Please ask for: Mrs D Johnson
Email: daun.johnson@arun.gov.uk
Telephone: 01903 737762
Our Ref: FG/123/20/PL
Your Ref:
Date: 8th October 2020

Application for Planning Permission

Development: Demolition of a polytunnel, storage building & scaffolders' shelters & racking, use of land for Class B8 container self-storage & the siting of 79 No. single-stacked storage containers, part regrading of the ground, new fencing, CCTV & lighting. This site is in CIL Zone 3 (Zero Rated) as other development & is a Departure from the Development Plan.

Location: Land At Former McIntyre Nursery Littlehampton Road Ferring BN12 6PG

DWG NO	REV
5320-2	C

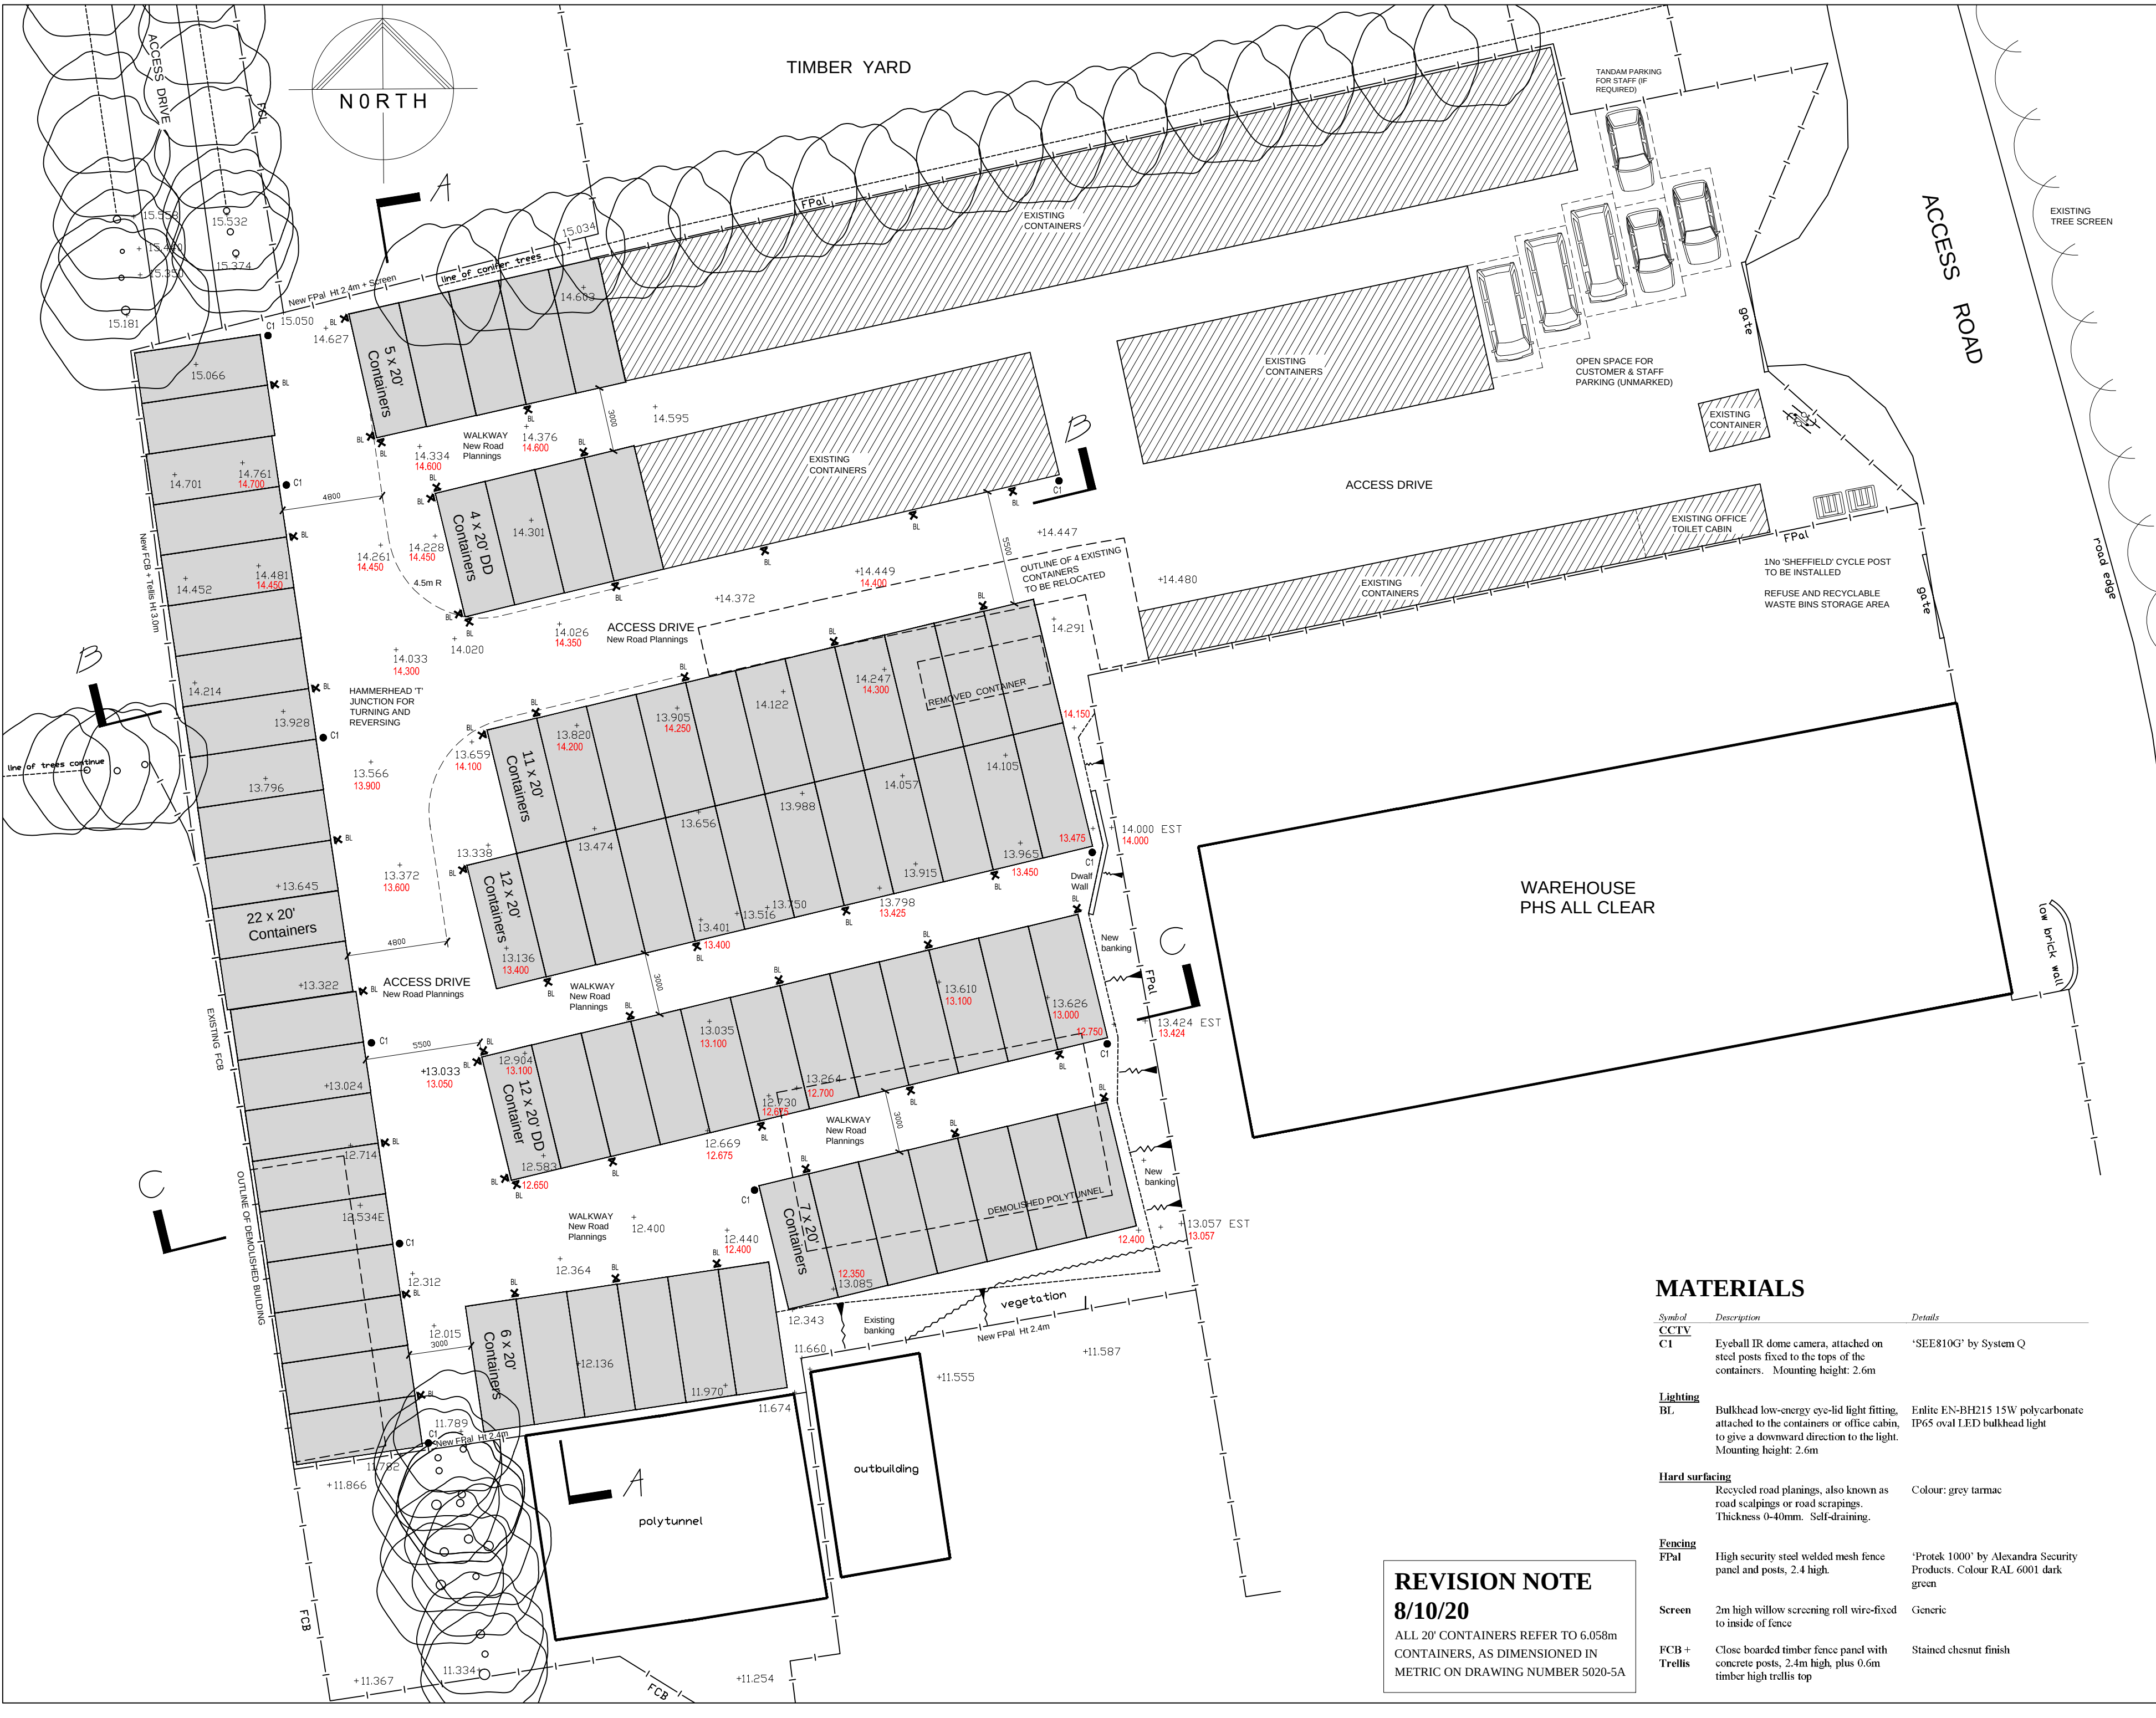
On plan 5320-2 Reva, please provide all measurements in metric and confirm what MDX4 denotes.
